Application No: AW/66/22/HH
Site Address: 36 Kingsway Aldwick PO21 4DH
Description of works: Addition of a first floor with pitched roof to the existing flat roof garage. This application affects the character & appearance of the Craigweil House Conservation Area.

Thank you for your internet representation made on 22nd April 2022 which has been recorded as an objection with the comments as follows:

Proposed West Elevation

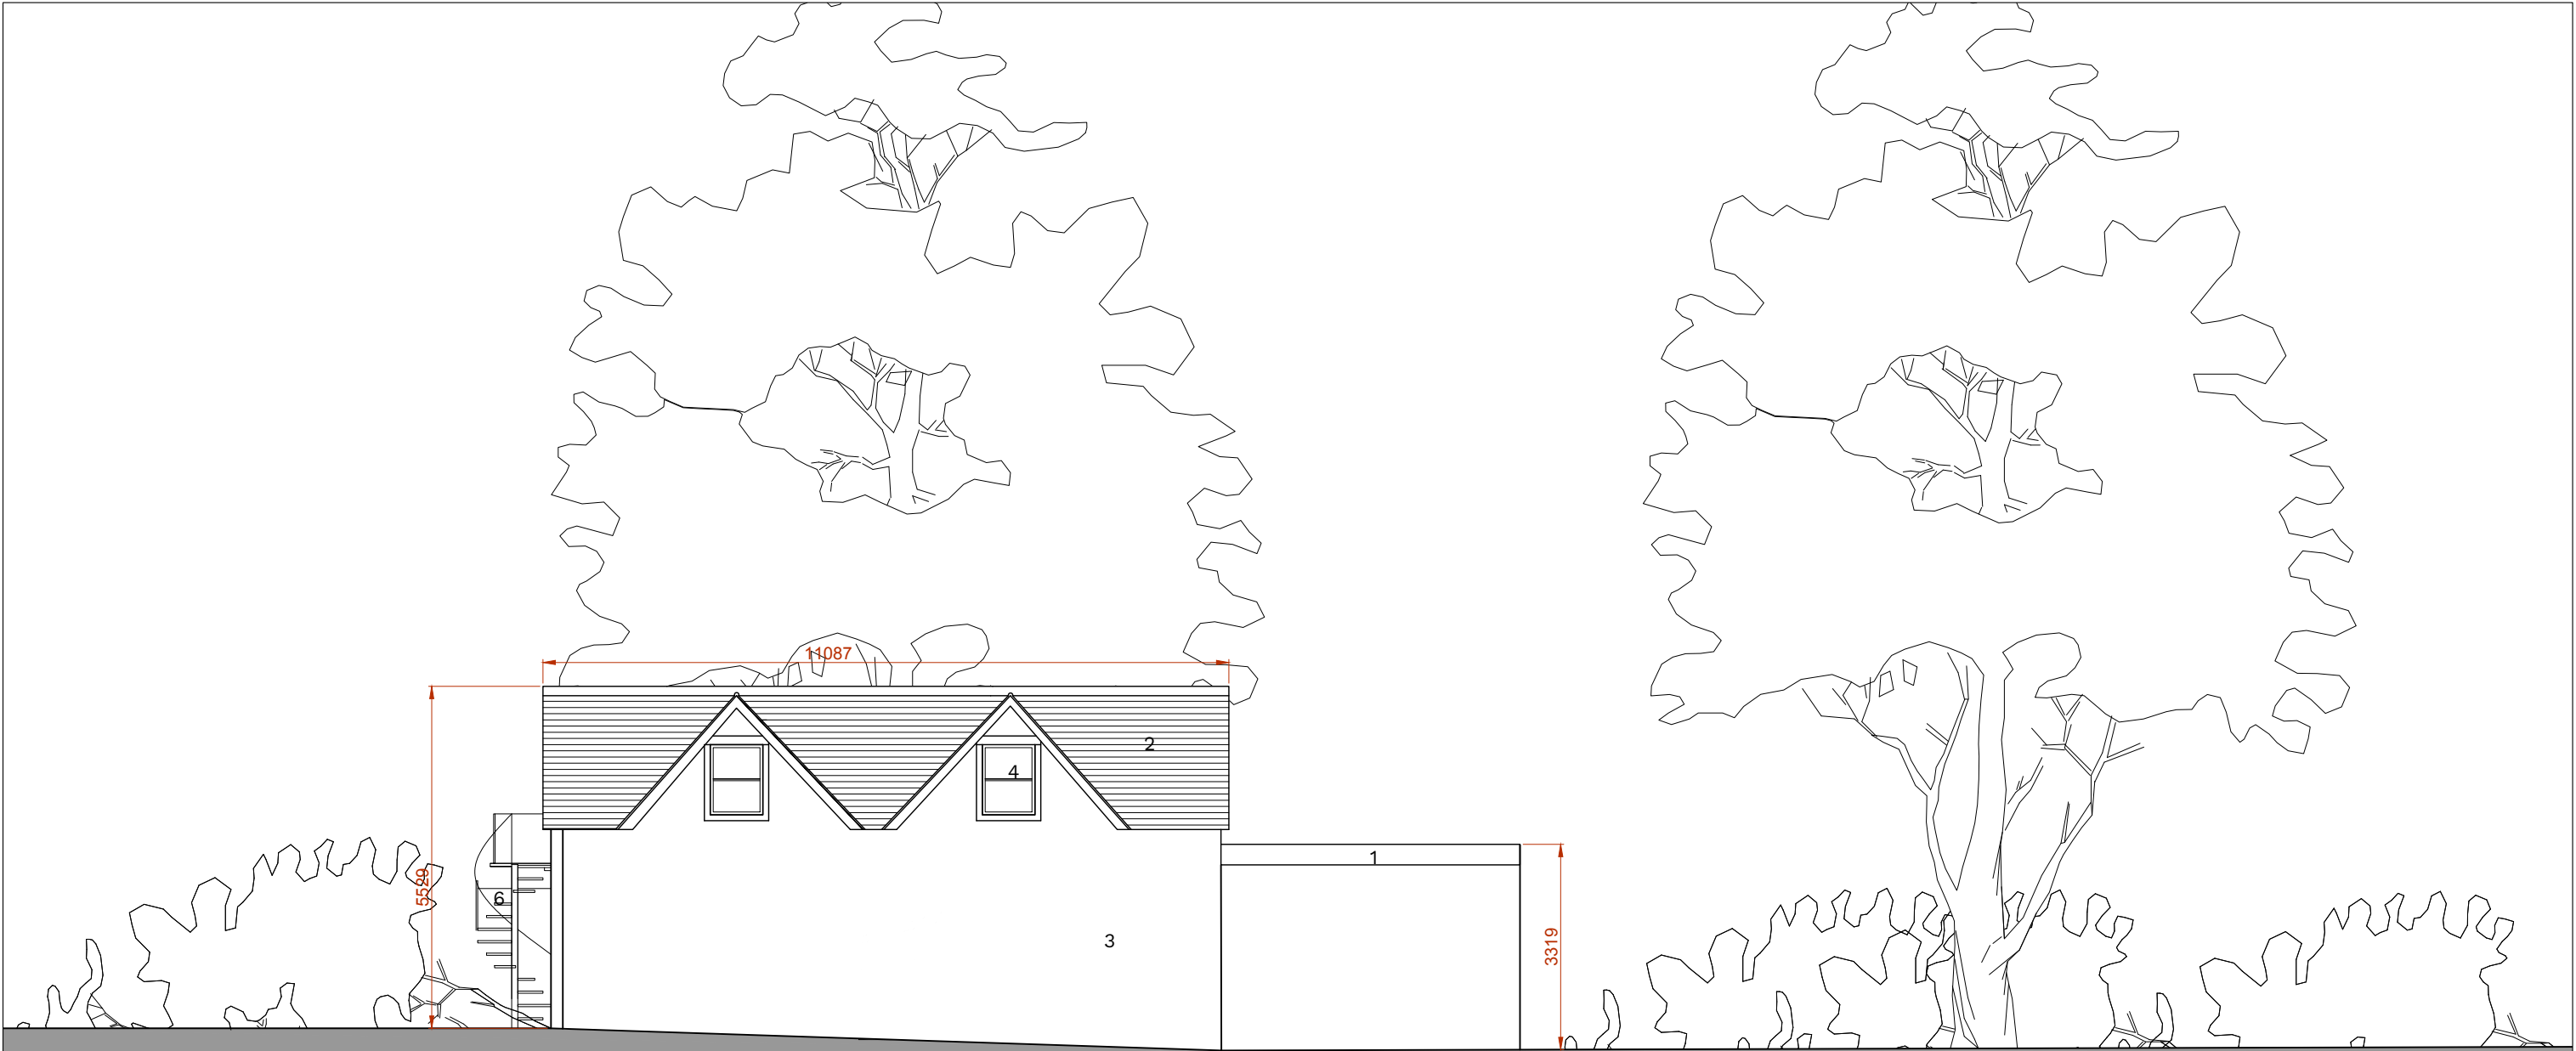
Proposed elevation is double that of the existing building which would overlook our property causing loss of privacy.

The height and scale of the proposed building, we believe, is detrimental to the street scene and out of keeping to the Conservation Area of Craigweil.

Developing such a large scale building on the boundary wall of No 34, will intrude on all the neighbouring properties.
